Ribble Valley Borough Council  
Council Offices  
Church Walk,  
Clitheroe  
Lancashire  
BB7 2RA

Phone: 0300 123 6780  
Email: [developeras@lancashire.gov.uk](mailto:developeras@lancashire.gov.uk)  
Your ref: 3/2025/0605  
Our ref: 3/2025/0605/HDC/KW  
Date: 10 October 2025

**Location:** Thoroughgoods 1 Whittingham Road Longridge PR3 2AA  
**Proposal:** Proposed erection of a 1-storey rear extension to create additional storage of the existing shop (Class E(a))  
**Grid Ref:** 360065 437102

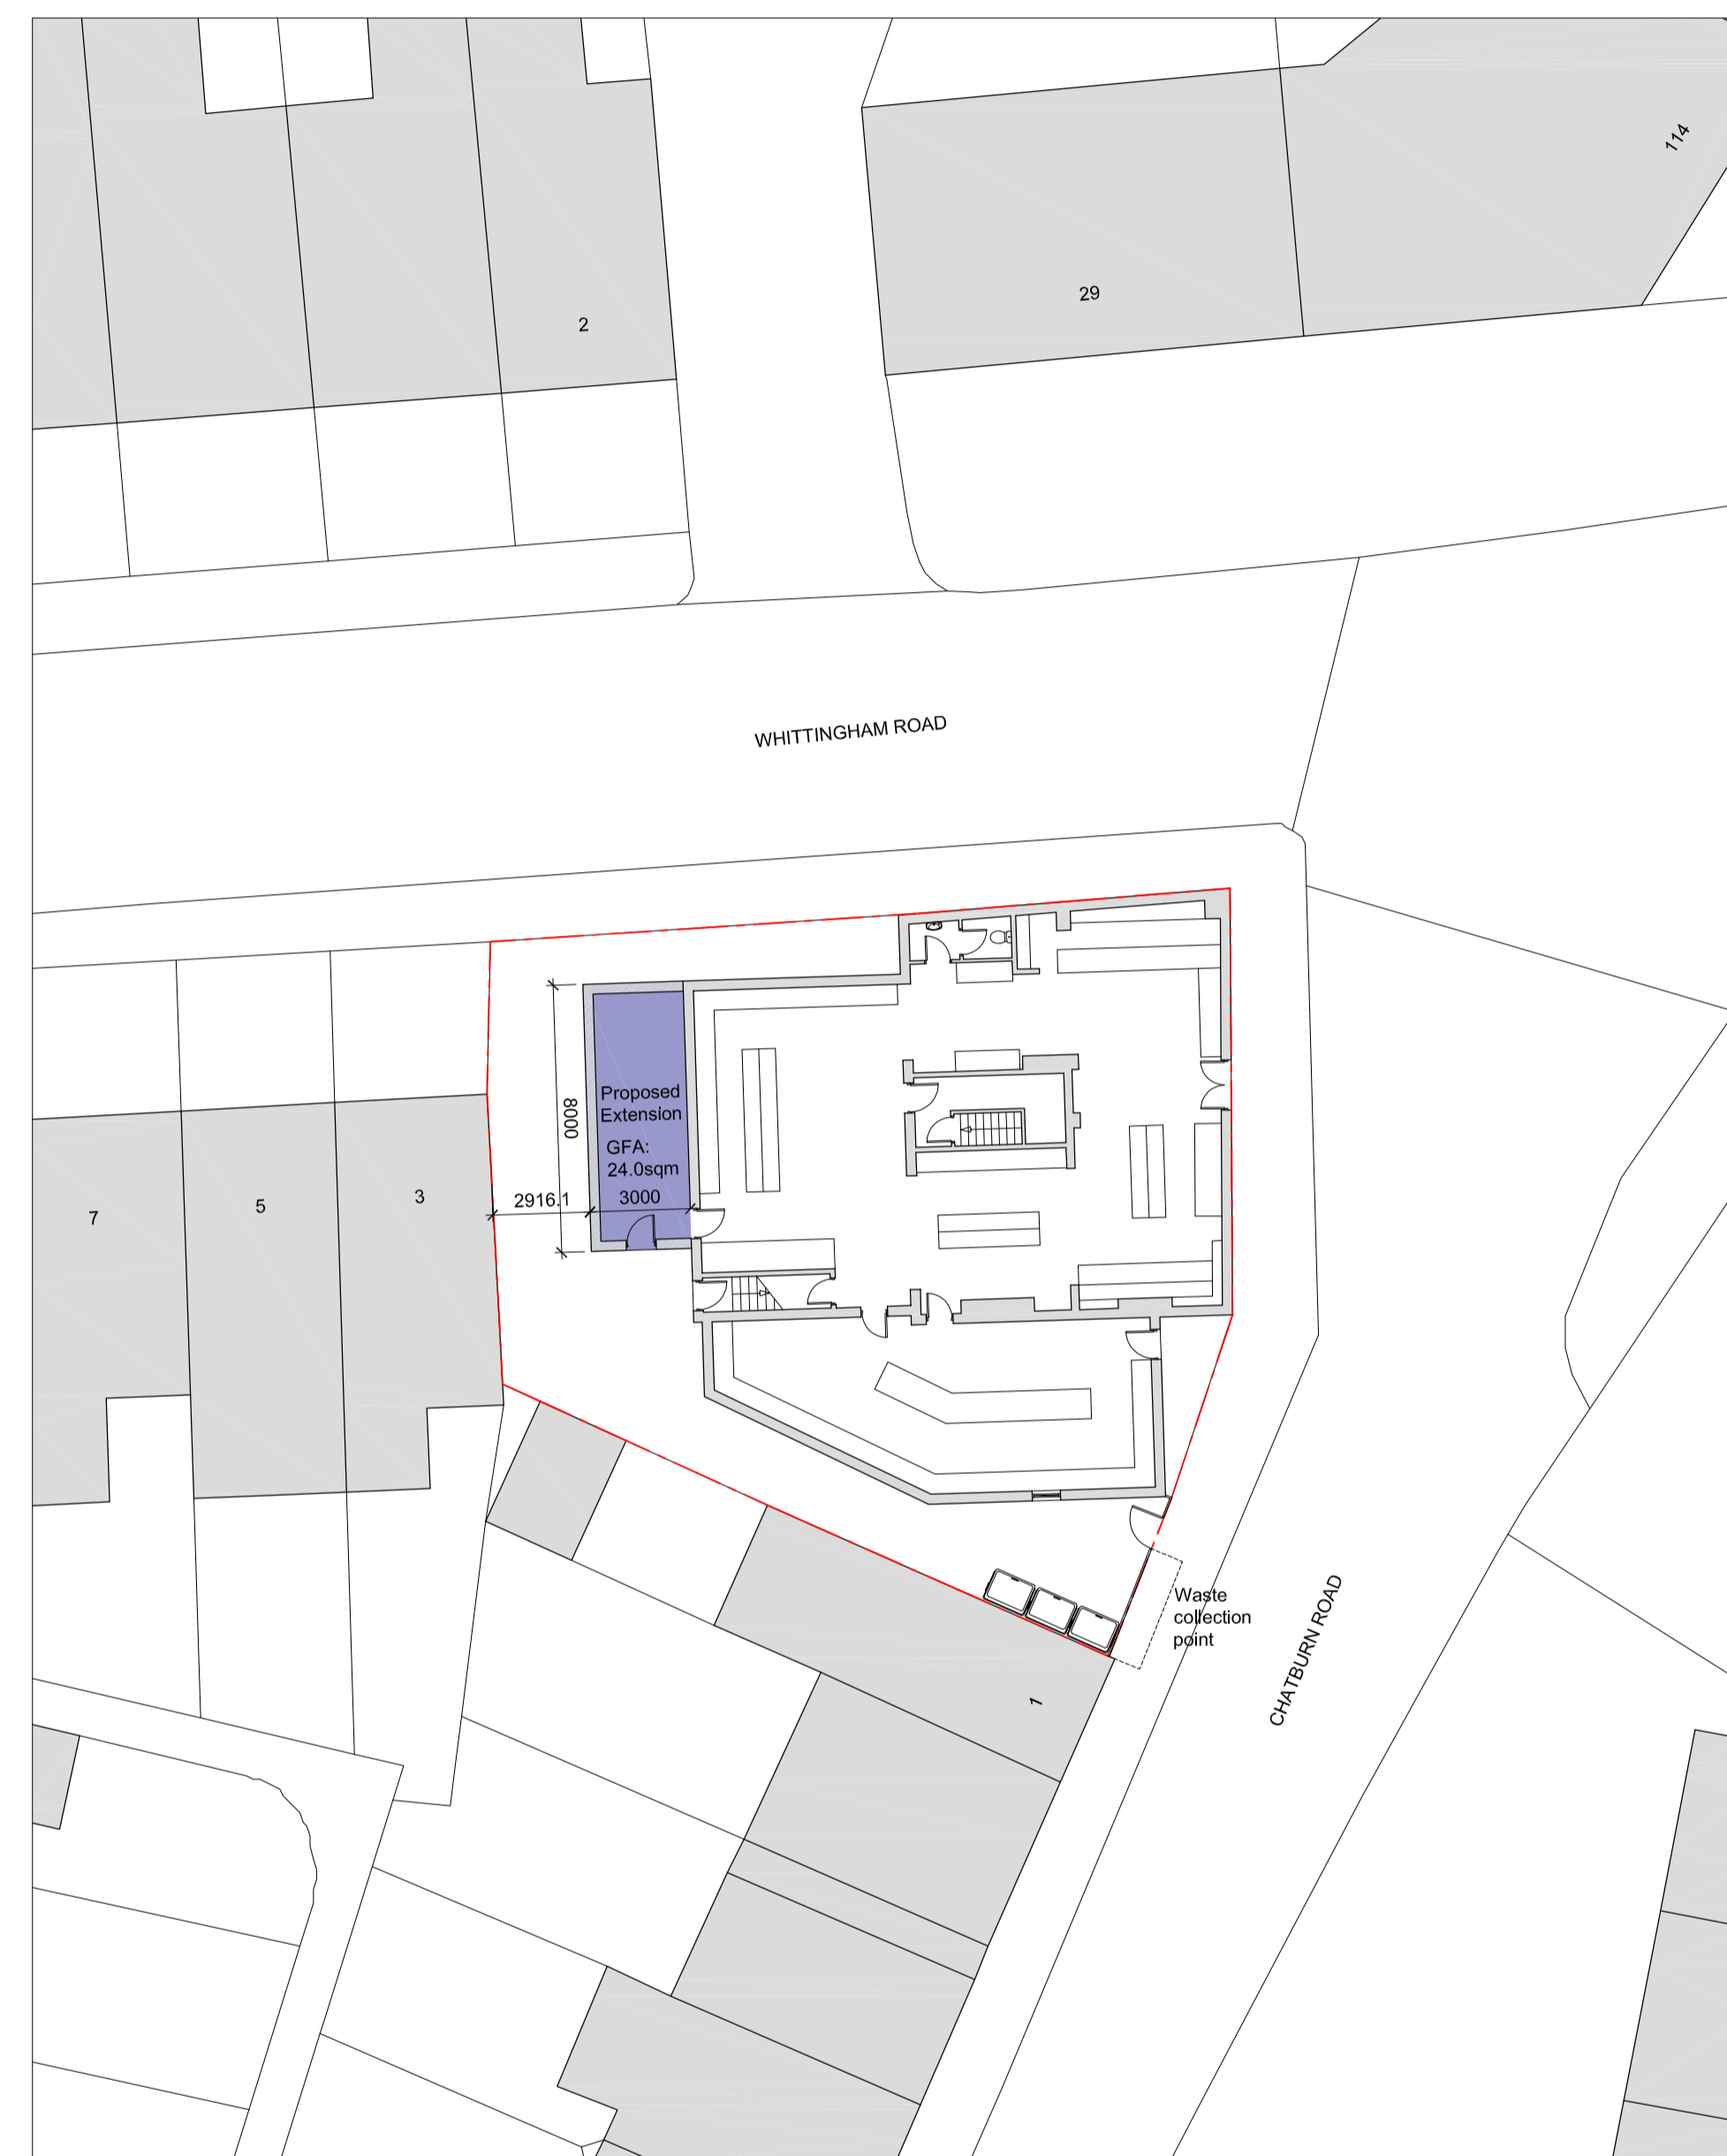
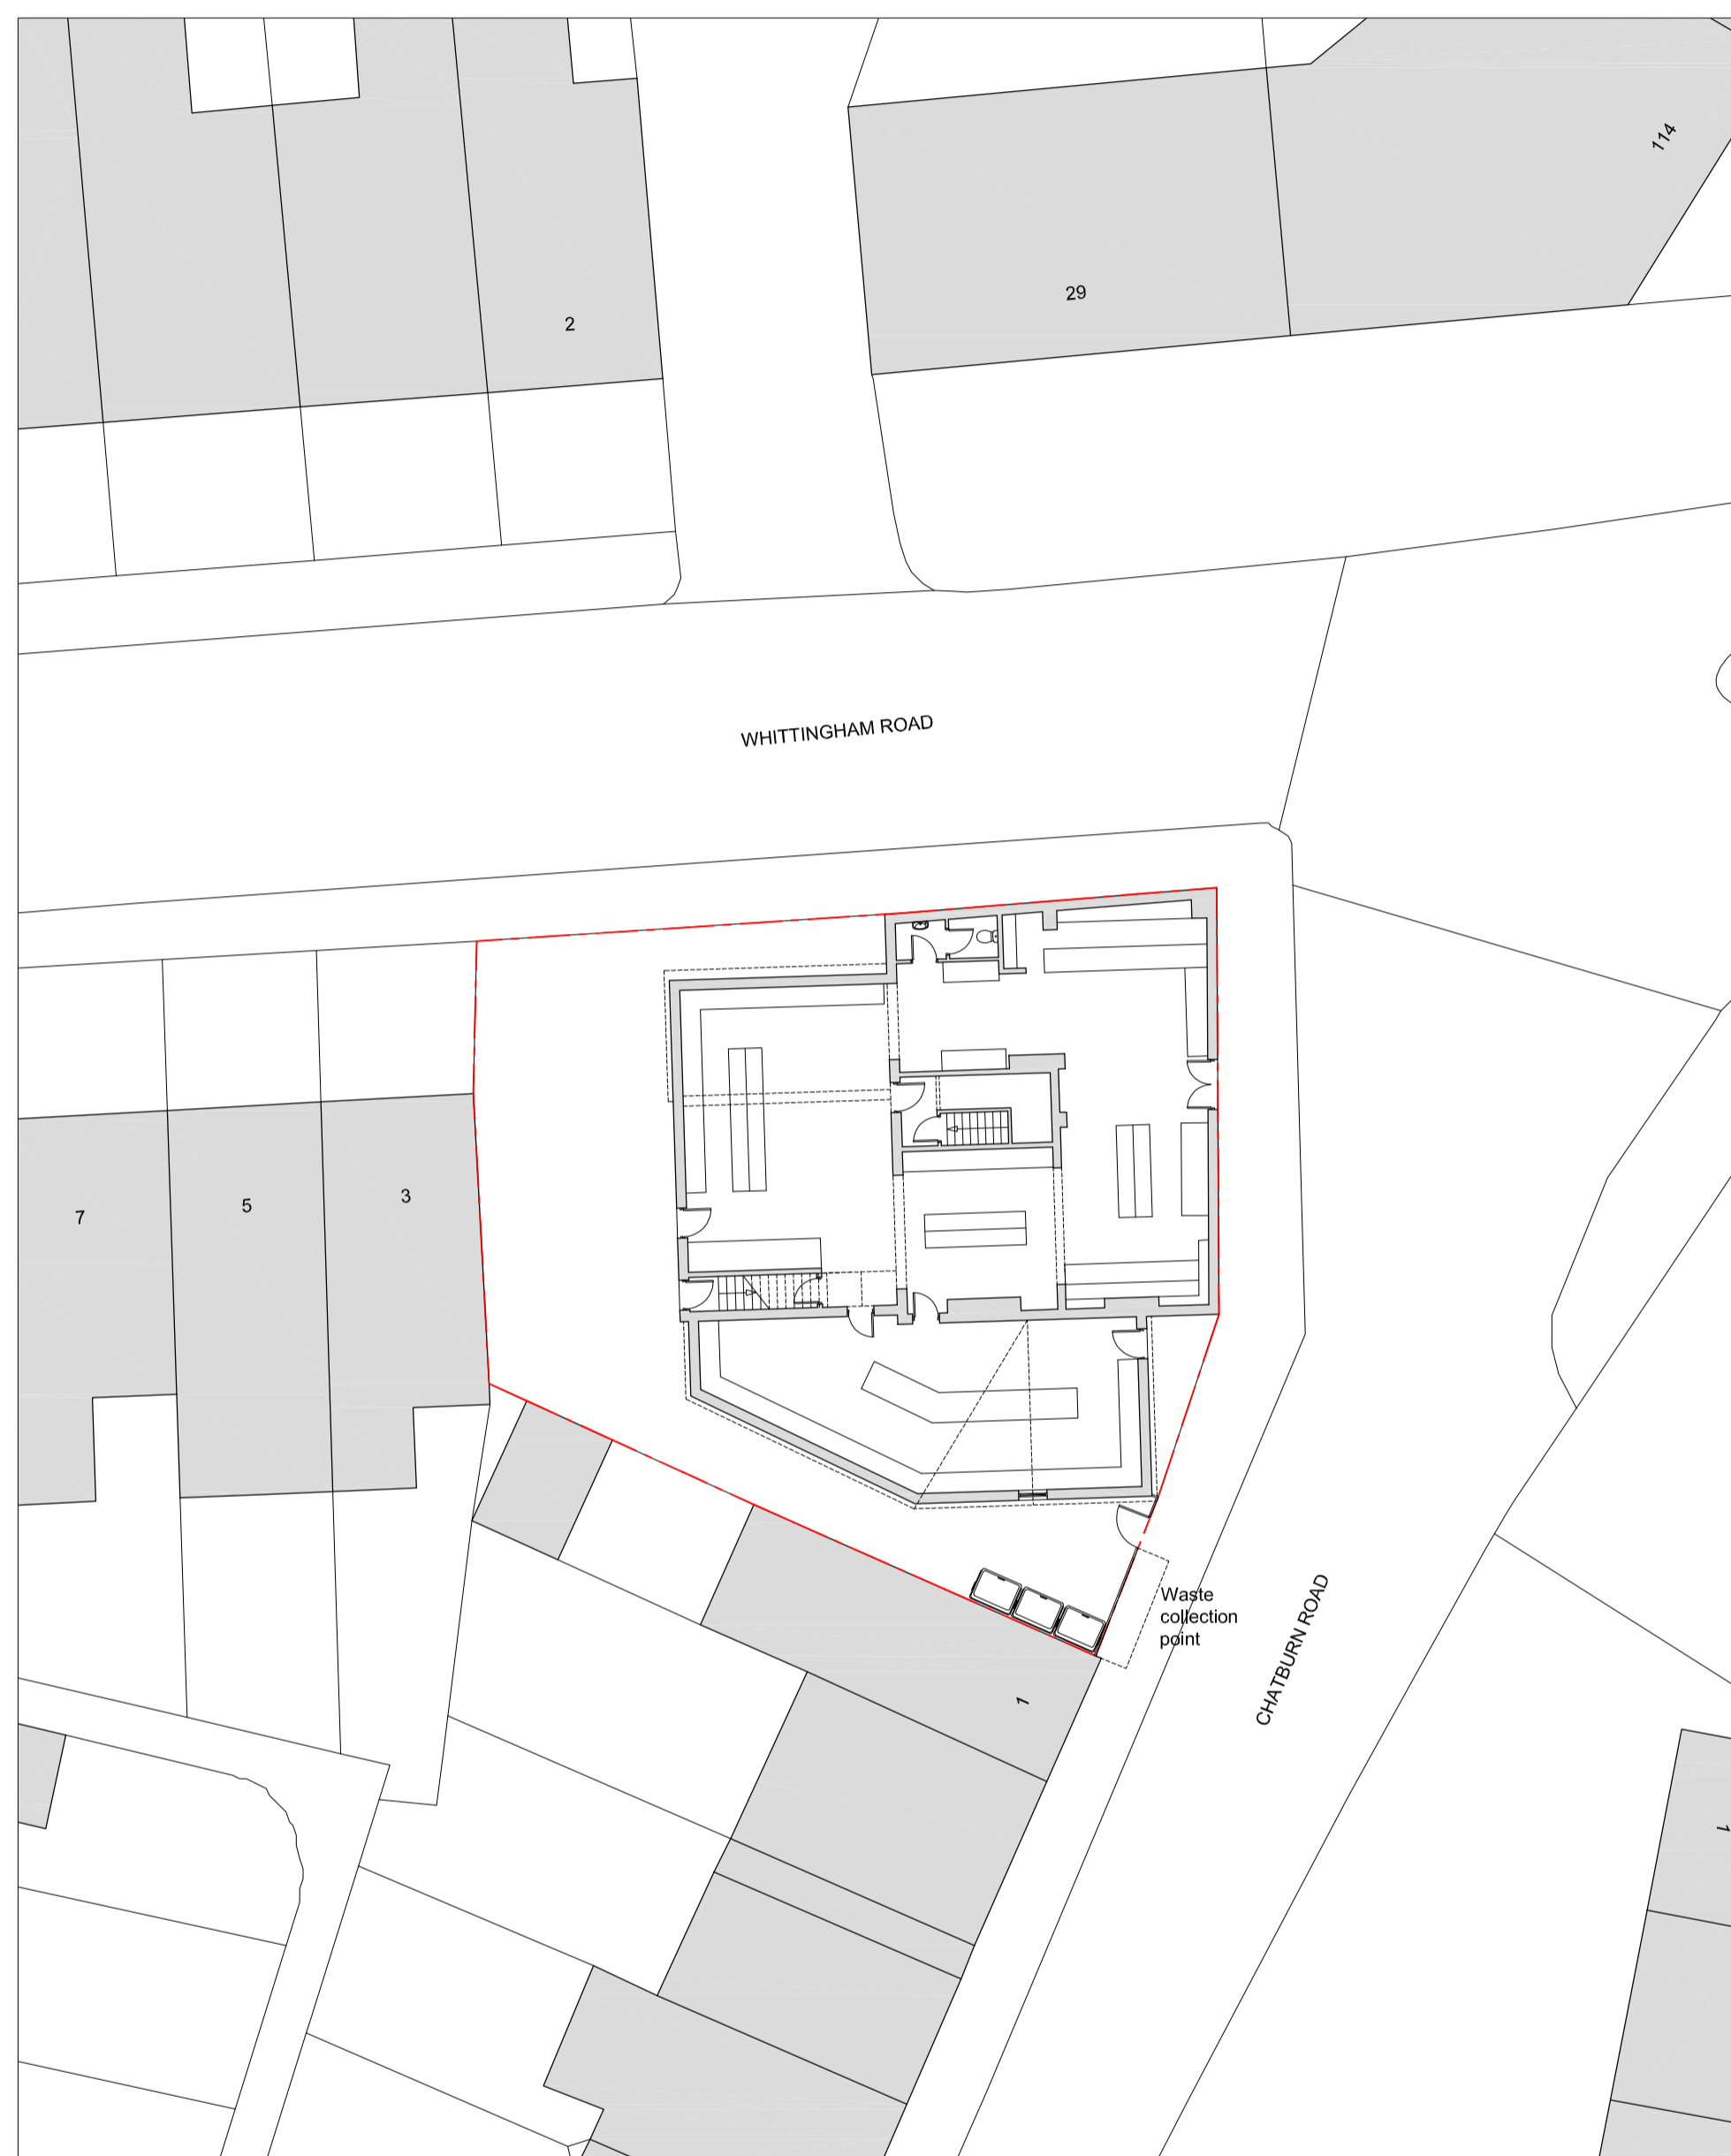
The site forms a shop on the ground floor level and a 4 bedroom dwelling on the first floor. A 4 bedroom dwelling should be provided with 3 off-street car parking spaces. These spaces should measure a minimum of 5m in length and 2.4m wide each, where they are

adjacent to a fence or similar obstruction an additional width of 0.6m should be provided. As stated within the LHAs parking standards as defined in the Joint Lancashire Structure Plan.

The shop would also benefit from internal parking provisions and internal servicing due to its location at the junction of Whittingham Road and Chatburn Road. Given the number of terrace properties and those without access to off-street parking on both Whittingham Road and Chatburn Road, there is likely to be a high demand for on-street parking in the area. The proposal will remove access to off street parking provision, intensifying the demand for on-street parking within the area.

In order to mitigate this concern, the applicant should provide an internal parking plan and a service management plan detailing how the shop will be serviced should the proposal be supported.
